Your Ref: A/83/18/RES

RE Land west of Brook lane and south of A259 Rustington BN16 3JL

Mr D Eaton
Planning Officer
Planning Control
Arun District Council

title
PROPOSED SITE ACCESS

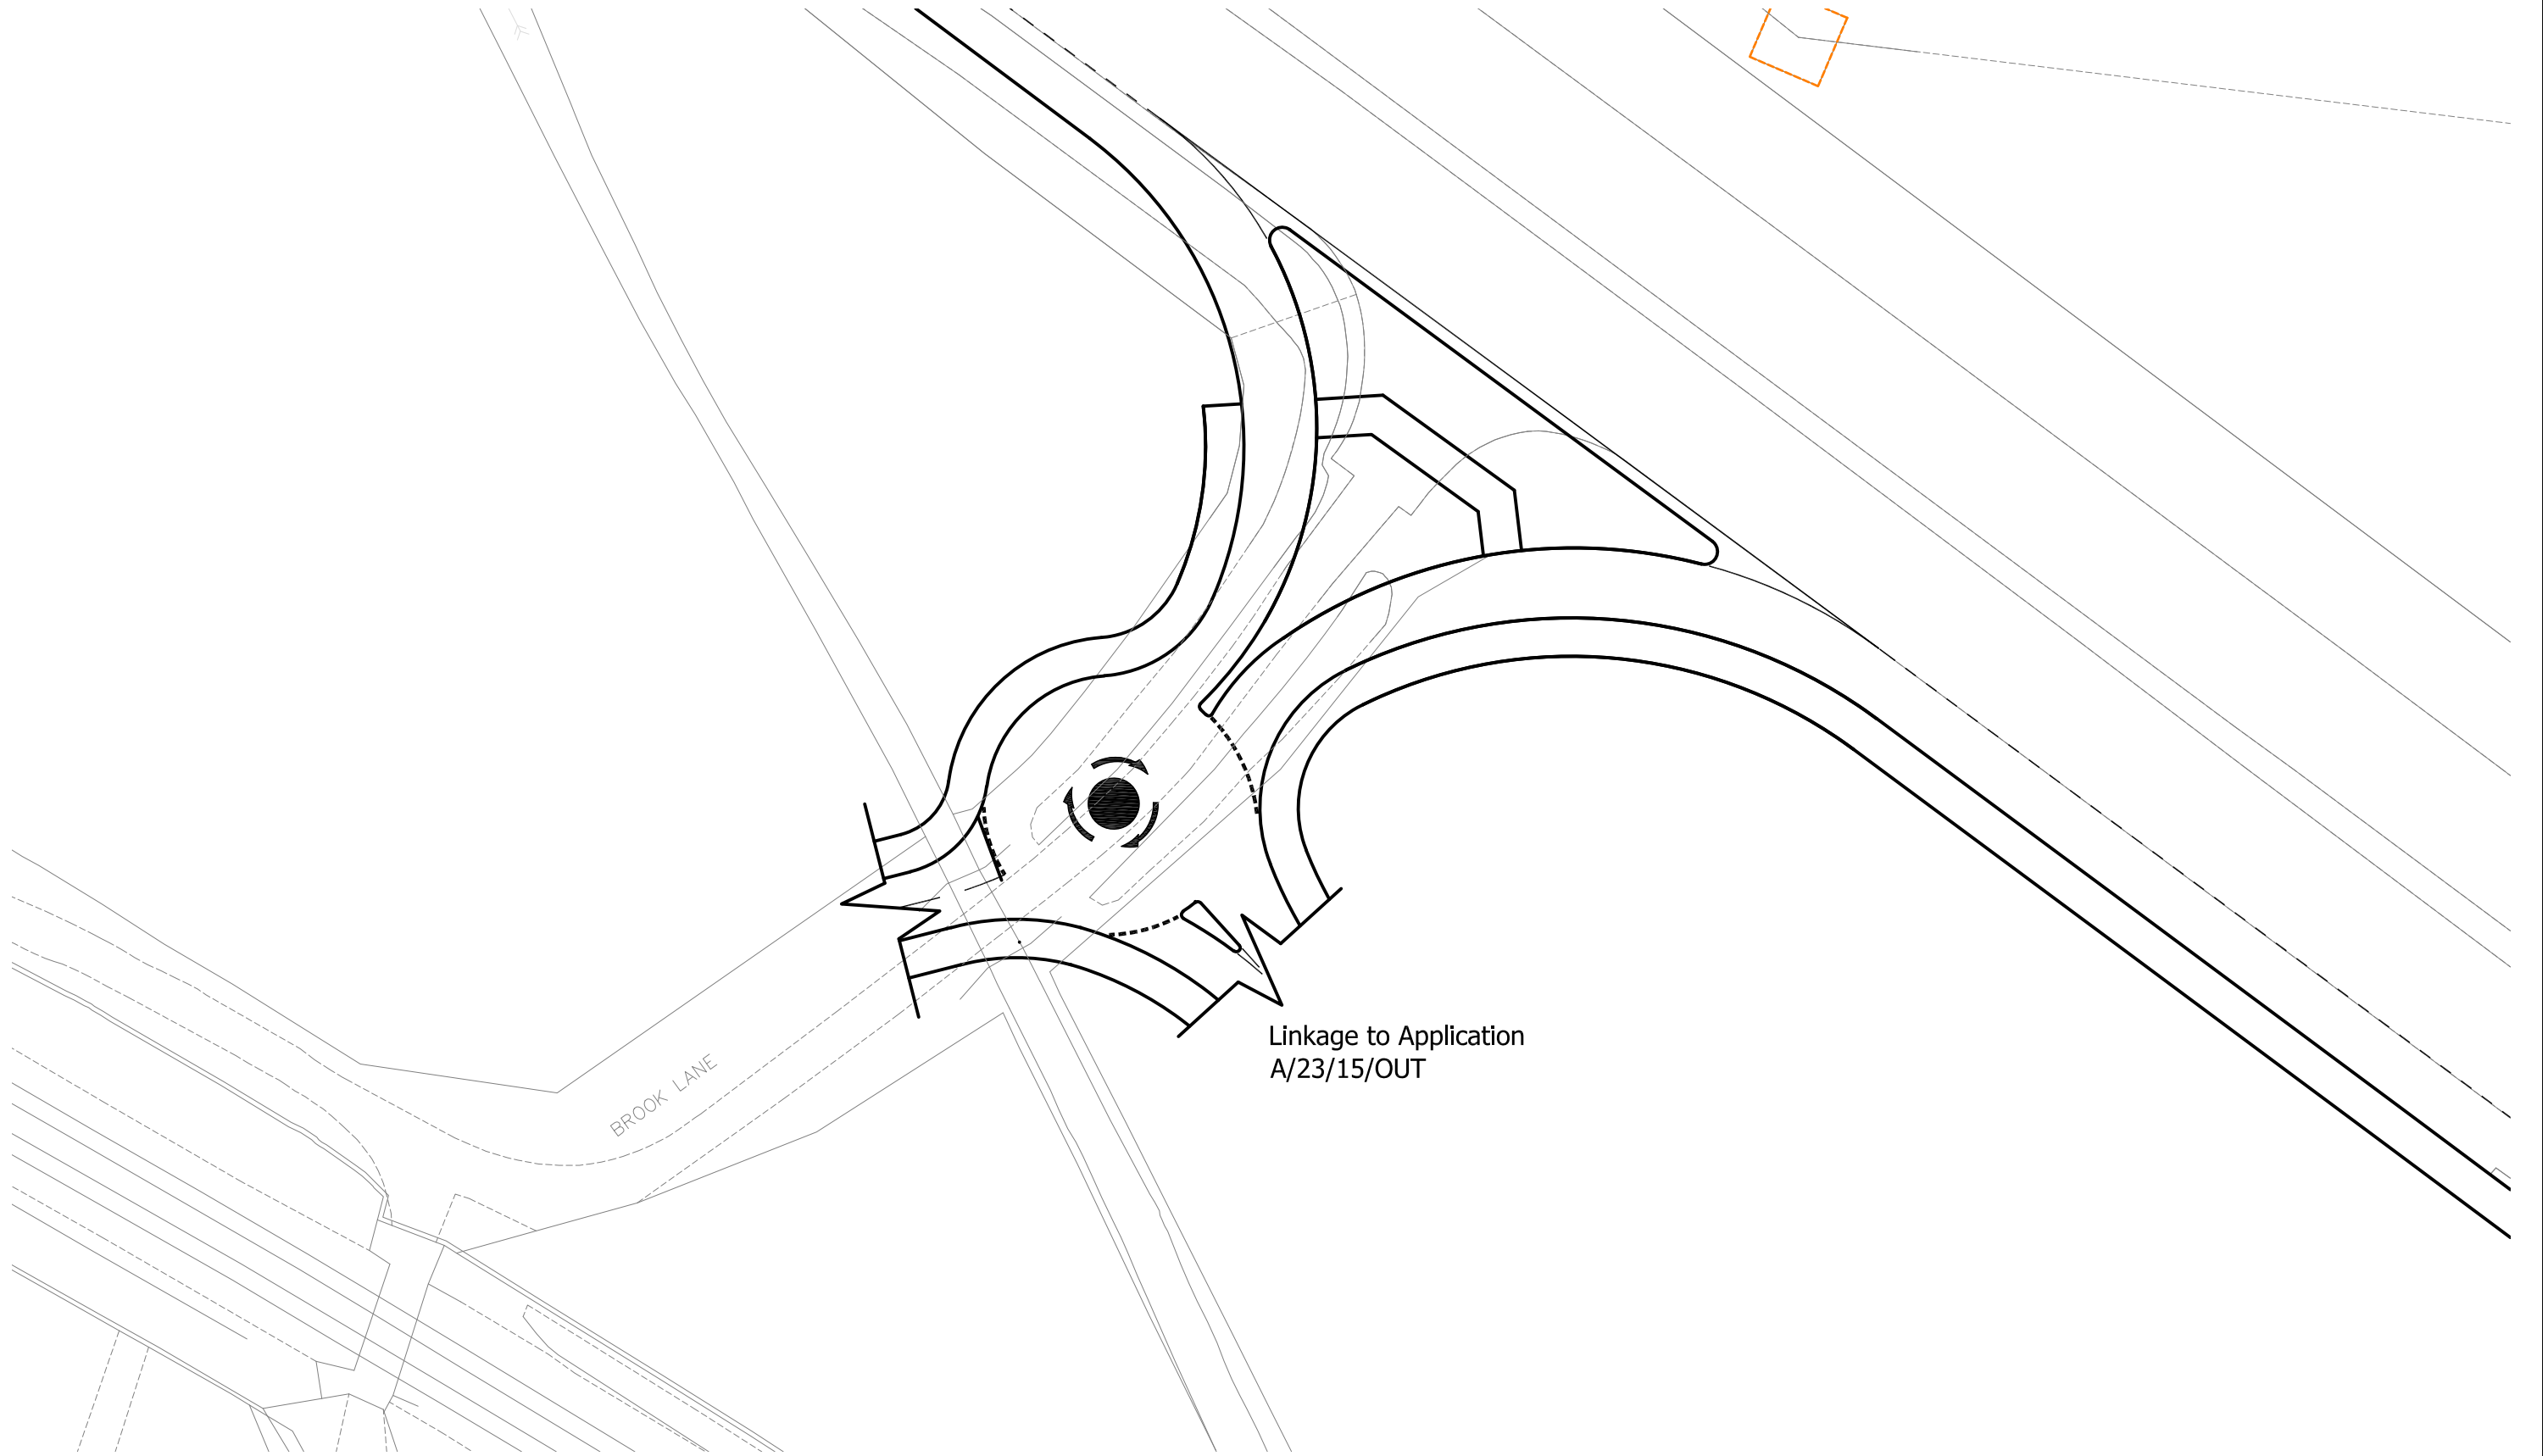
From a crime prevention viewpoint it is important that routes around and in to the development for pedestrians allow a good view ahead and around them. Foot paths should be straight, wide and well lit, be overlooked where possible and avoid potential hiding places and dangers from approaching road traffics.

The provision of a roundabout on the access road into Brook Lane leading from the south side of the A259 should provide a location for a crossing point for pedestrians wishing to access both the western or eastern developments and also provide a footpath to be directed along the southern side of the busy A259 where Commercial & Retail premises are located approximately 240 metres east of the proposed application. A crossing point at the roundabout should provide good visibility for drivers and pedestrians alike when entering the developments.

On new developments where isolated footpaths are unavoidable and where space permits footpaths should be 3 metres wide to allow people to pass without infringing personal space and to accommodate passing wheelchairs, cycles and mobility vehicles

Lighting throughout the development and its access roads will be an important consideration and should conform to the recommendations within BS5489:2013.
